From: Anita Gardner <Anita.Gardner@arun.gov.uk>
Sent: 21 July 2020 08:10
To: Planning.Responses <Planning.Responses@arun.gov.uk>
Subject: FW: CM/64/19/PL

From: Martin Gillam [REDACTED]
Sent: 19 July 2020 12:06
To: Anita Gardner <Anita.Gardner@arun.gov.uk>
Subject: CM/64/19/PL

Now that the architect has included some measurements it is clear that the location of the house is too close to mine and not conforming with Council planning guidelines – see below.

Drawing Title:
STREET SCENES/SECTIONS

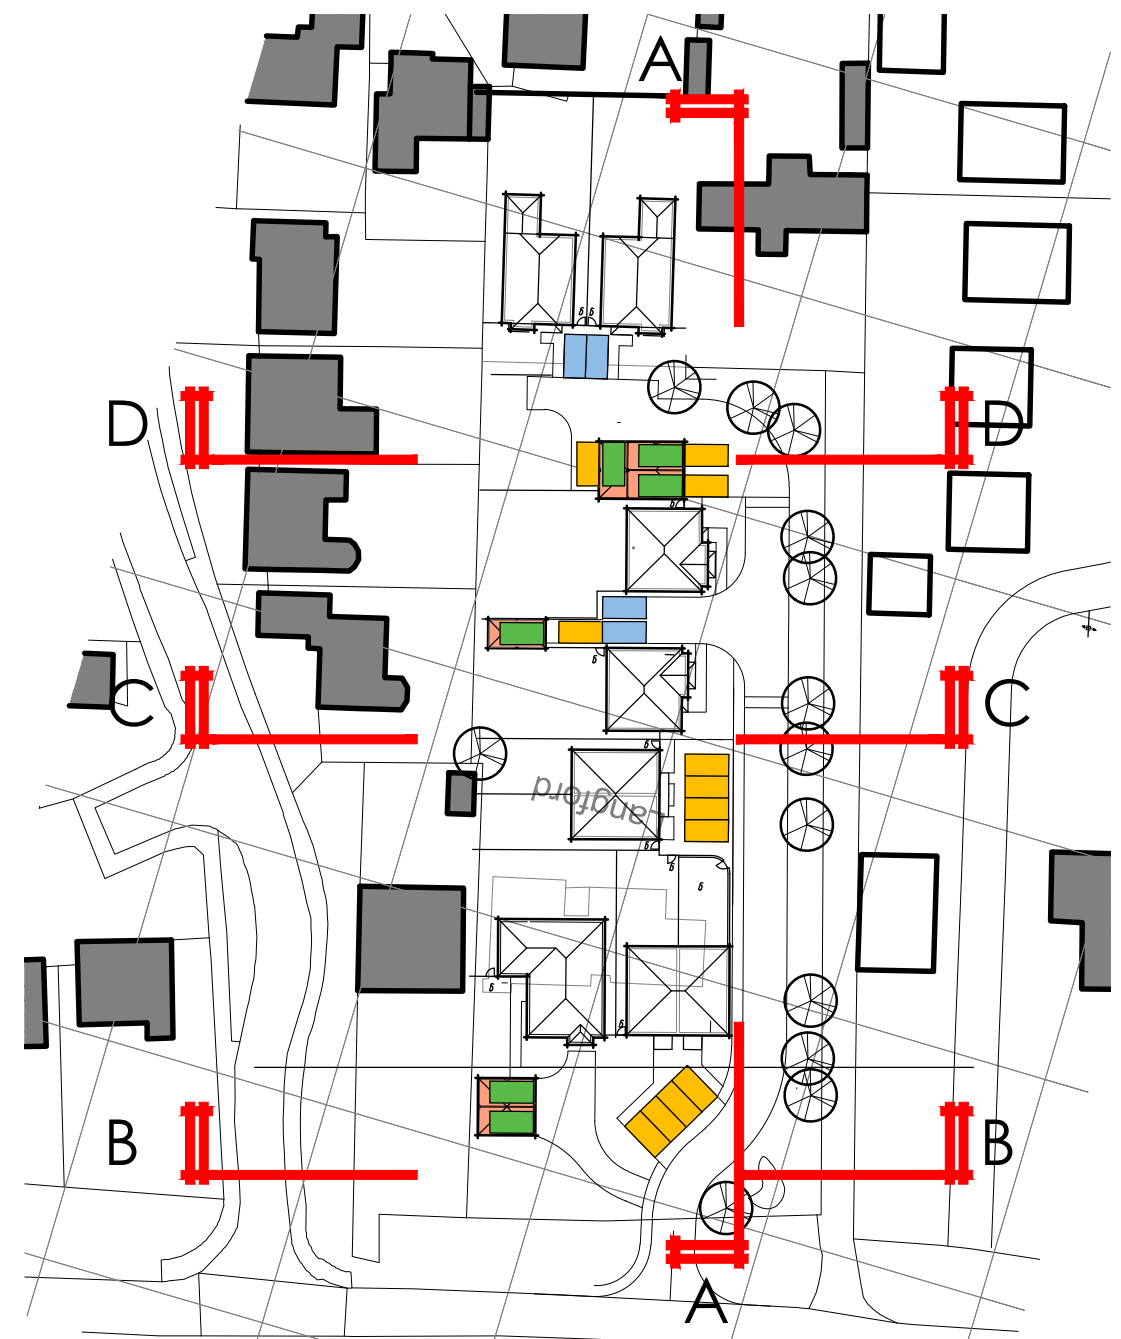
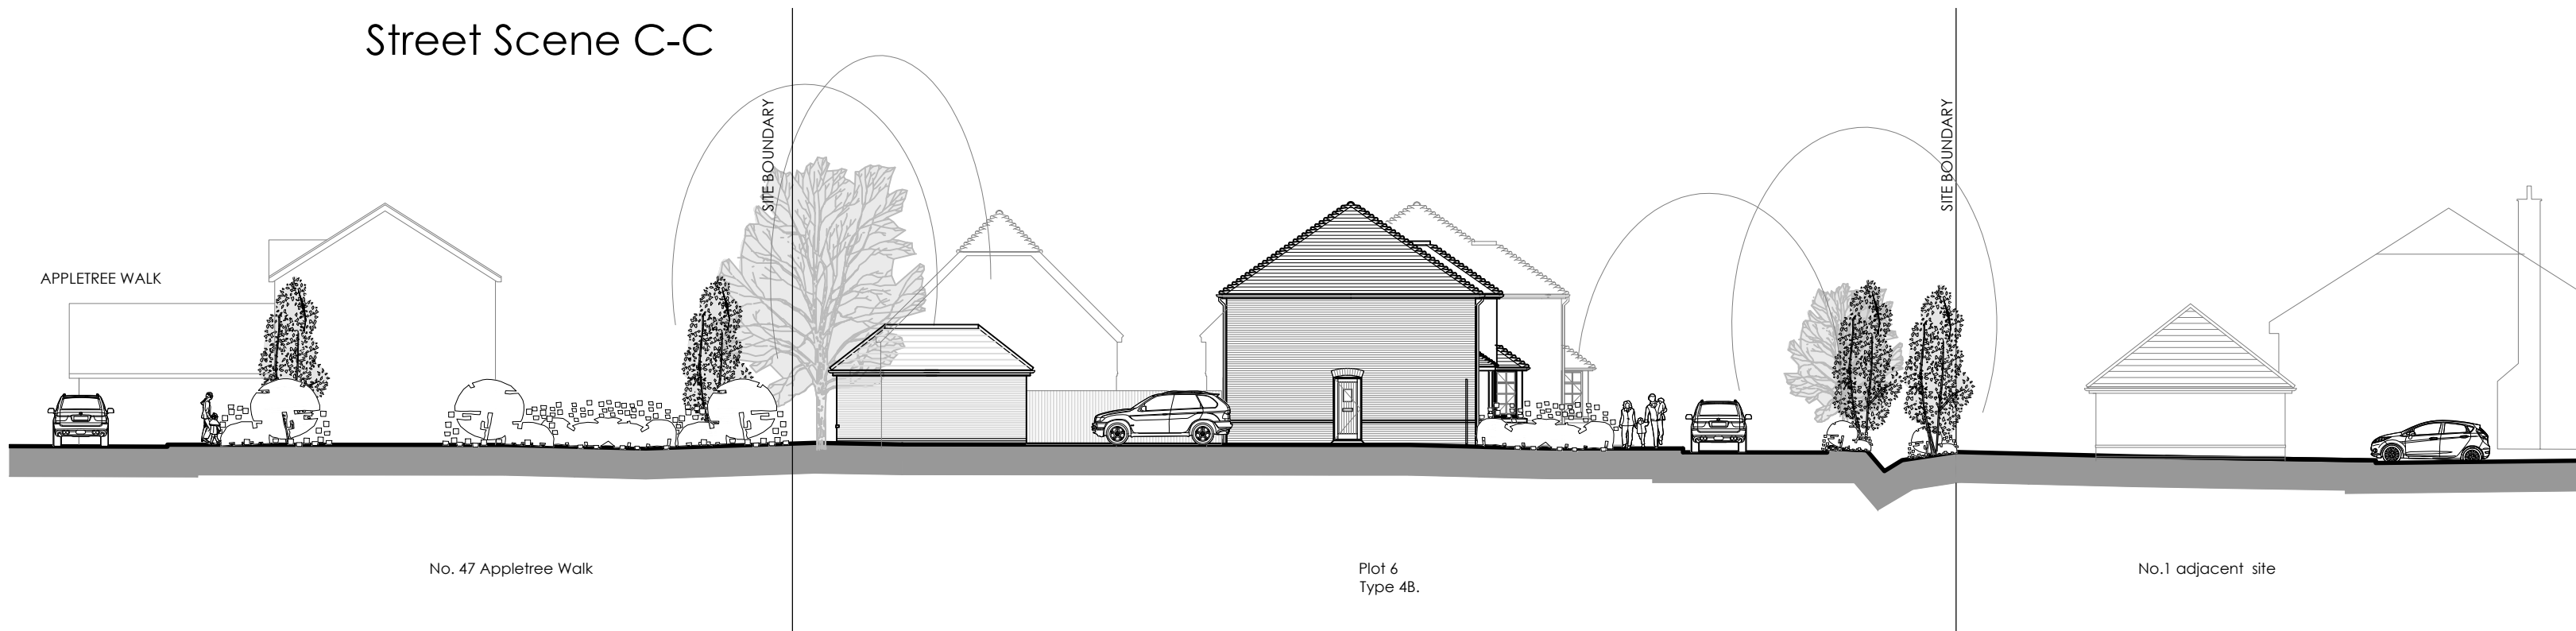
Clearly there is a significant difference between the latest technical drawings plans and the outline planning approved. The house appears longer, higher and closer to my house than the original plans submitted. This may be due to it being "based on construction/technical drawing to ensure the actual internal dimensions/clearances are being achieved" or it could be they have altered the internal height of the ceilings but whatever the reason the design has been significantly altered and as such plot 8 needs to be reassessed for planning permission.

Drg No: 190725/SL-01
Rev: K

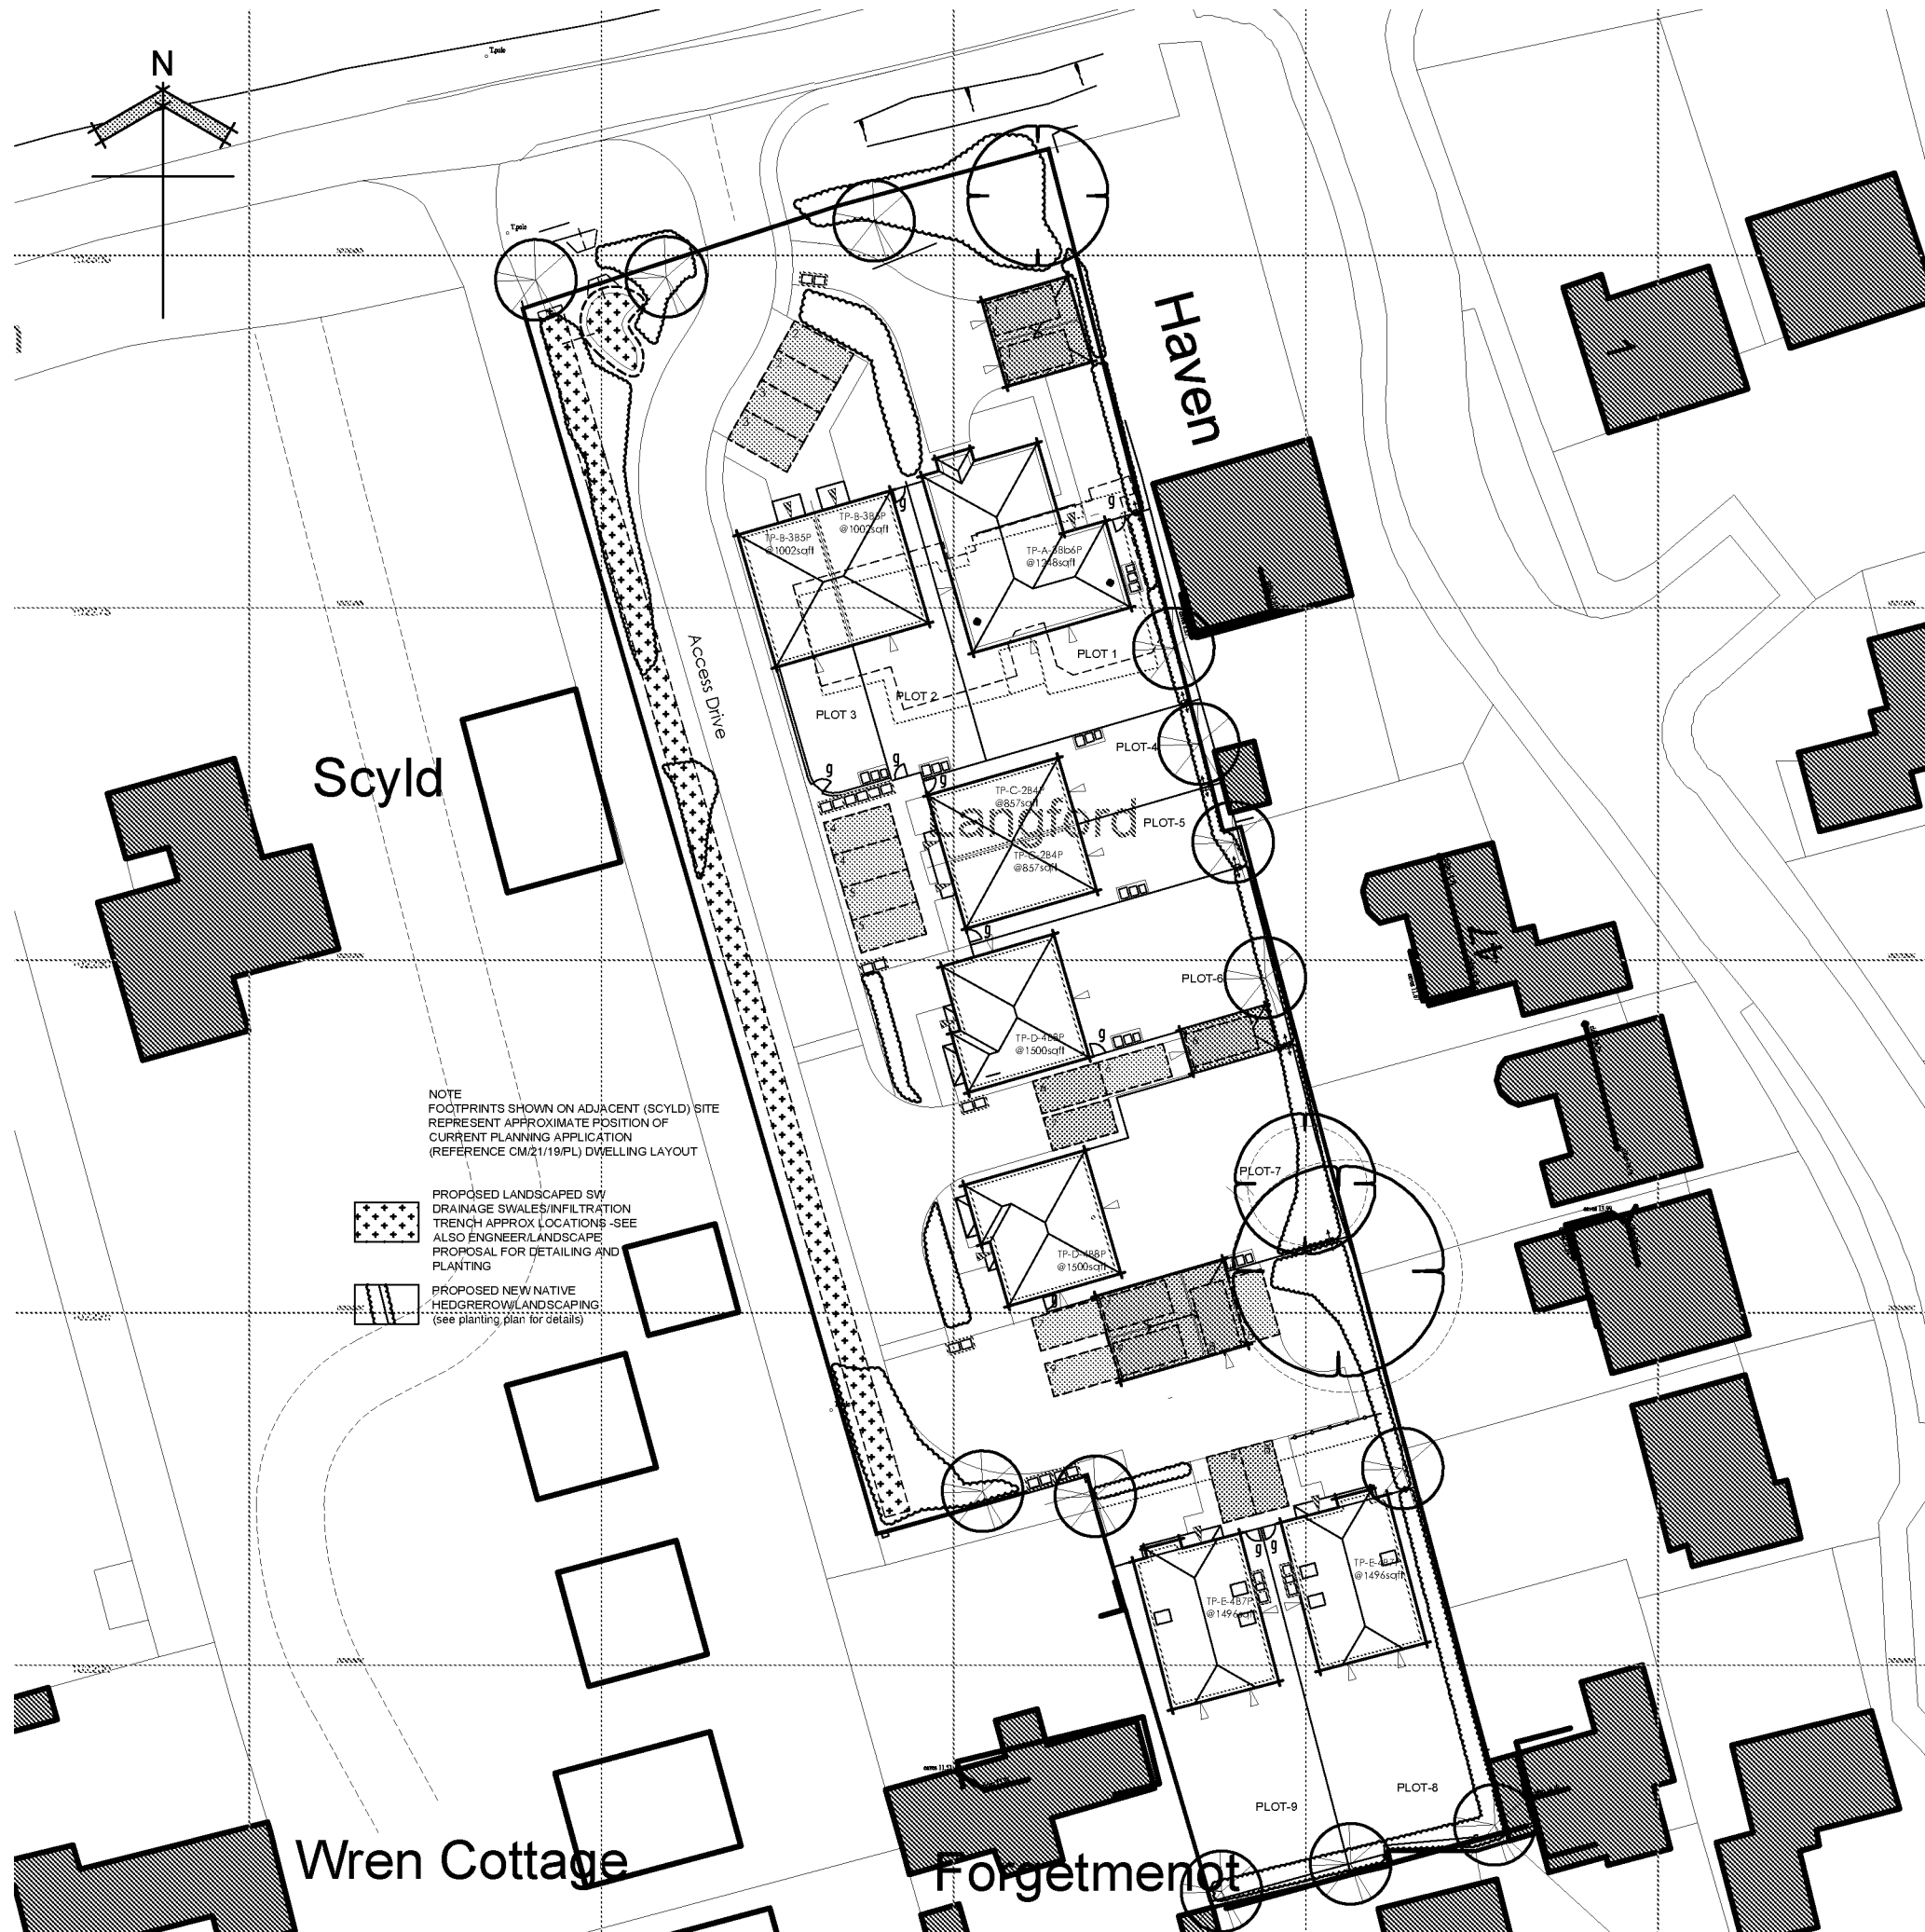
The applicant has stated that they need to locate the house 7.3m from my property to enable car parking at the front of the house, so not only does the design and location have to change but also parking arrangements. Consequently planning for Plot 8 should be revoked.
